Project Name: Meridian Ranch, Filing #8A

Project Number: SF-17-010

Description: Approval is being requested to adjust the common lot line between Lots 11 & 12 of Meridian Ranch, Filing #8 and forming Meridian Ranch Filing #8A, Lots 11A & 12A. These lots are located at 12542 & 12530 Culebra Peak Drive in Section 19, Township 12 South, Range 64 West.

MERIDIAN RANCH FILING 8A  
A REPLAT OF LOTS 11 AND 12, MERIDIAN RANCH FILING NO. 8,  
LOCATED IN THE SE<sub>4</sub> OF SECTION 19, TOWNSHIP 12 SOUTH,  
RANGE 64 WEST OF THE 6th P.M., EL PASO COUNTY, COLORADO

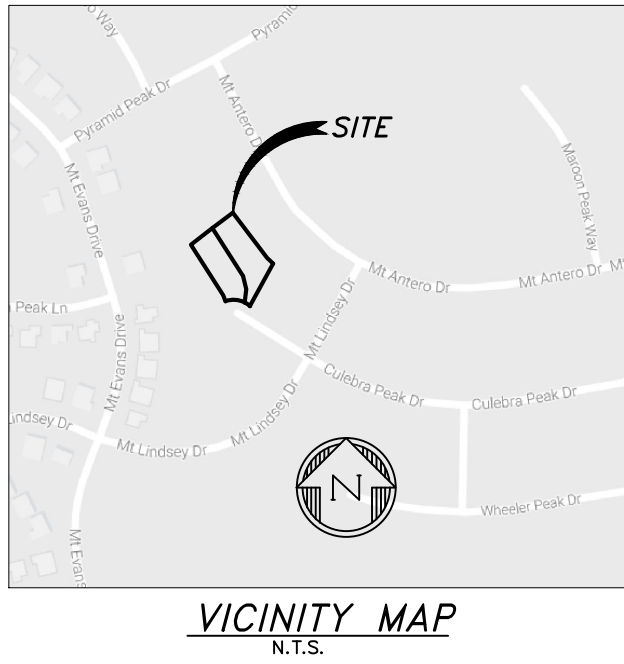
This area is within MVEA certificated service area and MVEA is currently serving consumers along Culebra Peak Drive according to our extension policy. With the change in the common lot line of Lot 11 and 12 of Meridian Ranch #8 the electric facilities may no longer be located in an acceptable location and the lot design may require the facilities need be moved. If the facilities are move to better serve the consumers effected, it will be at the expense on the applicant prior to relocation.

MVEA has no objection to the lot line adjustment between Lots 11 & 12 of Meridian Ranch #8, except for the concerns with the placement of the electric facilities.
